Date: 08/06/2024

Re: **Damaged Roof Truss**
Location: Lot 57 Wellers Knoll (92 Wild Turkey Way Lillington, NC)
JDS Project No.: RDU2408005
Date of Inspection: 08/06/24

S-6b
ROOF FRAMING
PLAN

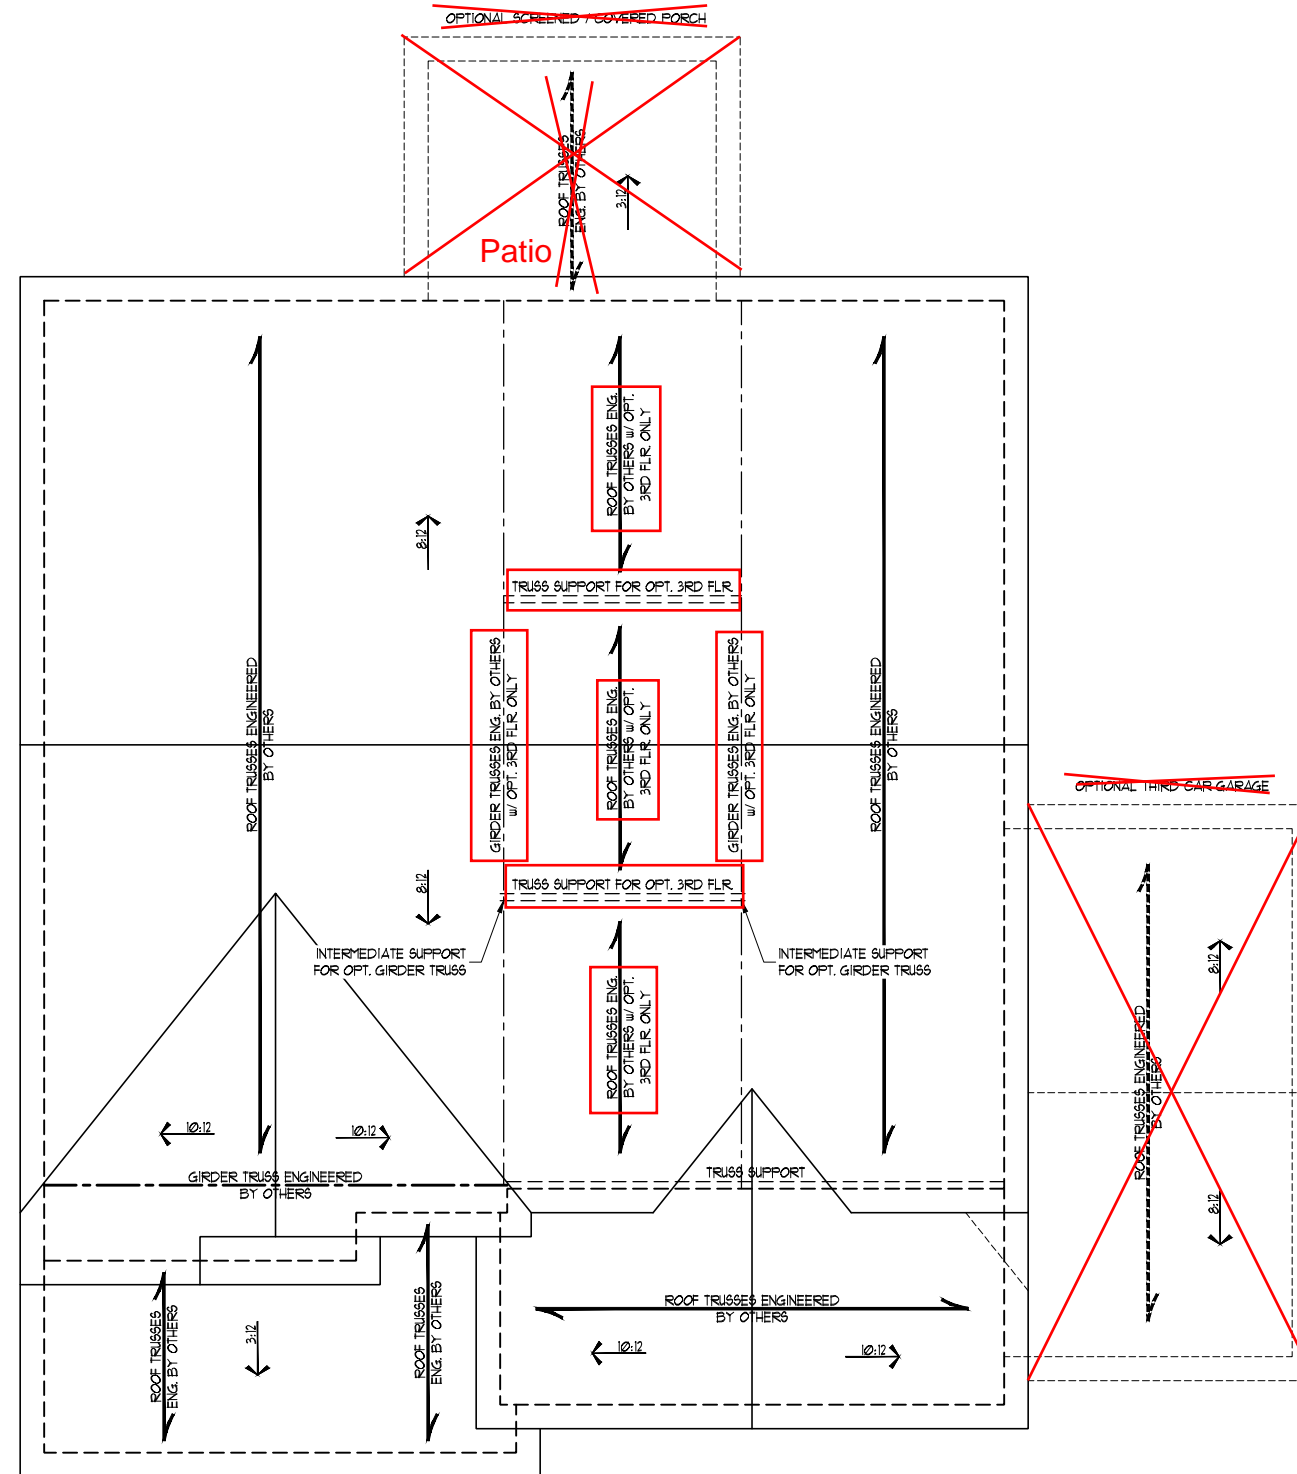
The client requests an evaluation of the 2nd through 5th roof trusses from the right in the rear attic space has damaged gusset plates.

Based on our on-site observations and review, install 16"x16"x7/16" osb gussets on both sides of each roof trusses attached with (2) rows of 10D nails spaced at 4" o.c. in each covered member. Where there is ladder blocking it may be relocated as needed.
